Our ref: Hills Showground Precinct East-Mod-2 (SSD-62802207-Mod-2)

Subject: Request for Additional Information

I refer to your modification application for the Hills Showground Precinct East-Mod-2 (SSD-62802207-Mod-2). After careful consideration, the Department is requesting the following additional information before finalising its assessment of your application:

BUILDING A- ELEVATION COMPARISON

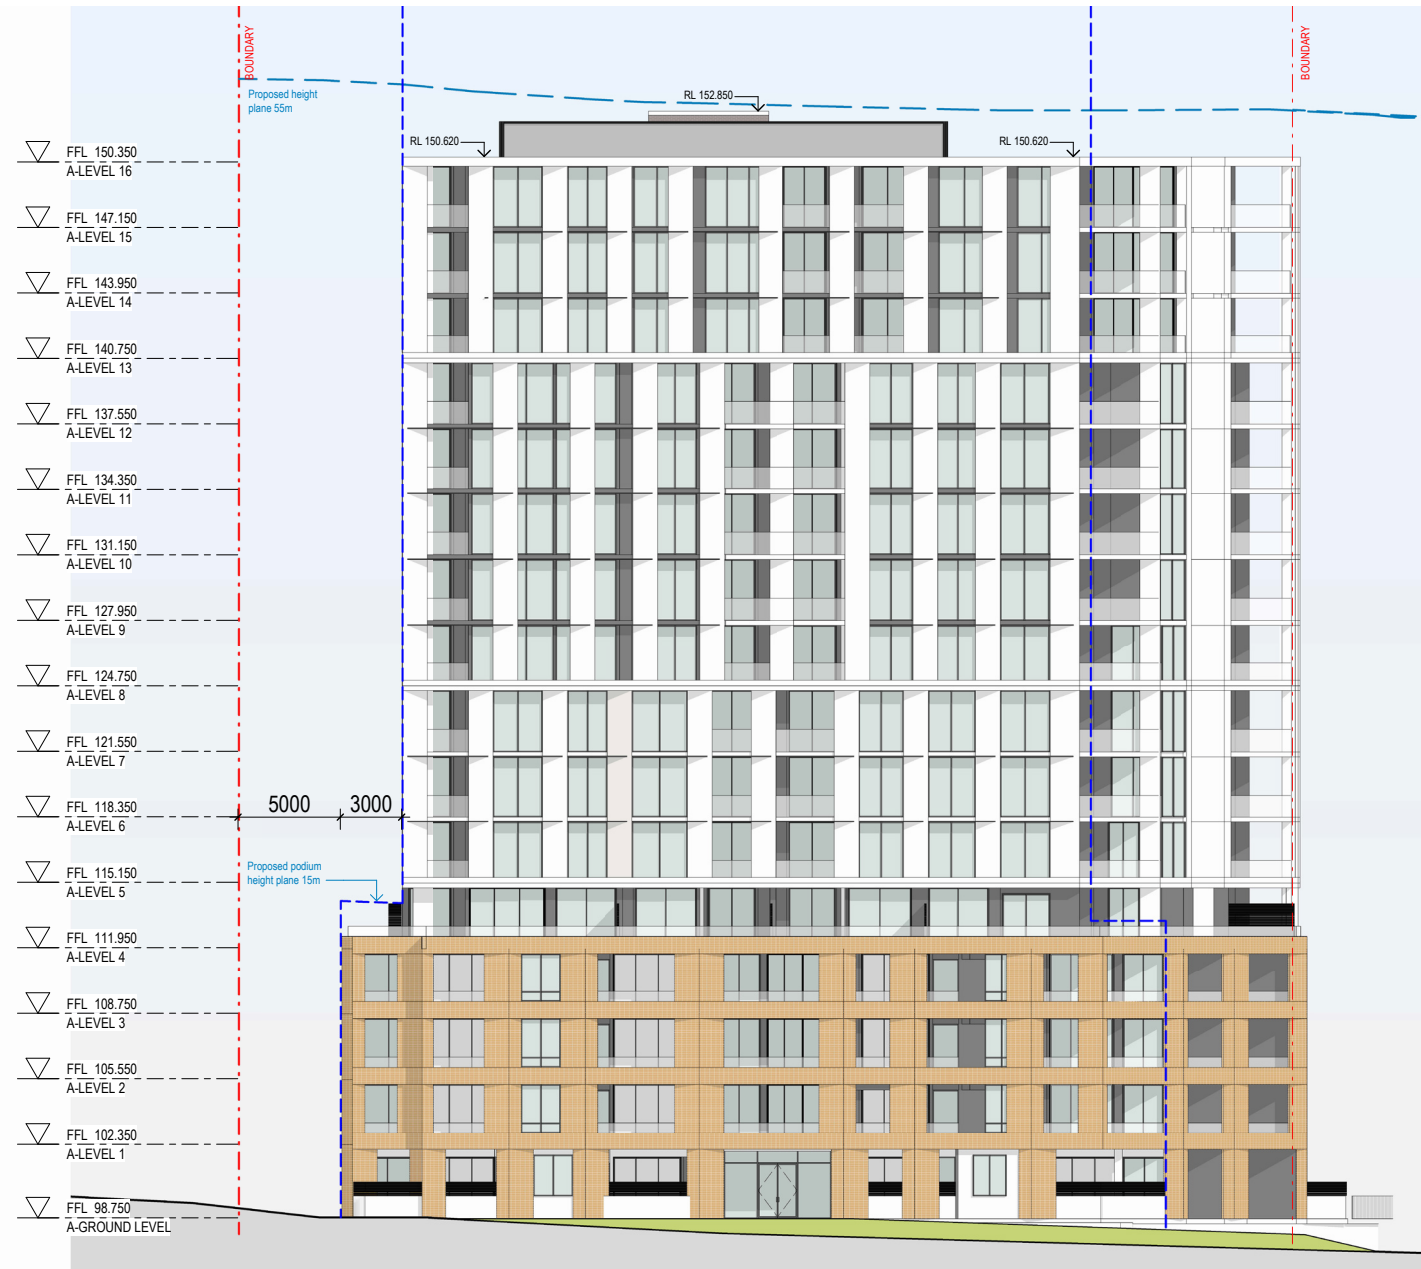
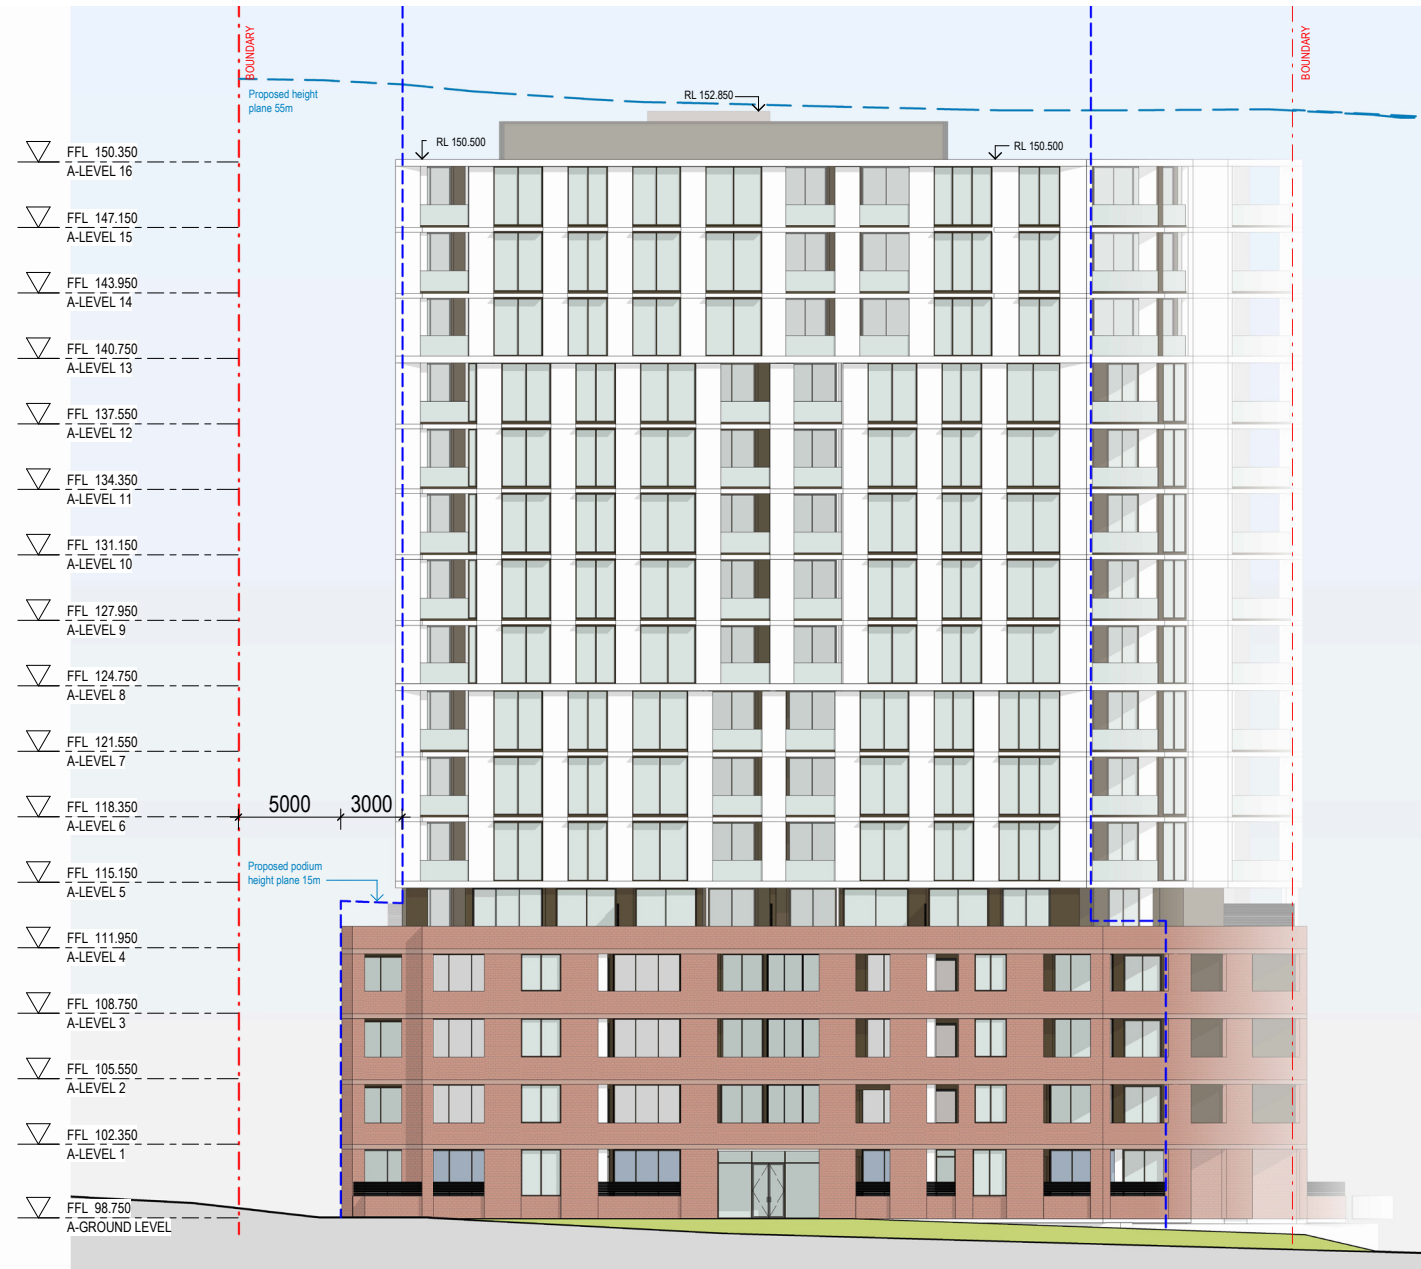
- a) Provide further details, specifically at podium level, demonstrating the proposed design and material changes do not diminish the design integrity of the approval.
- b) Reconsider and replace the proposed use of painted finishes with alternative quality finishes.
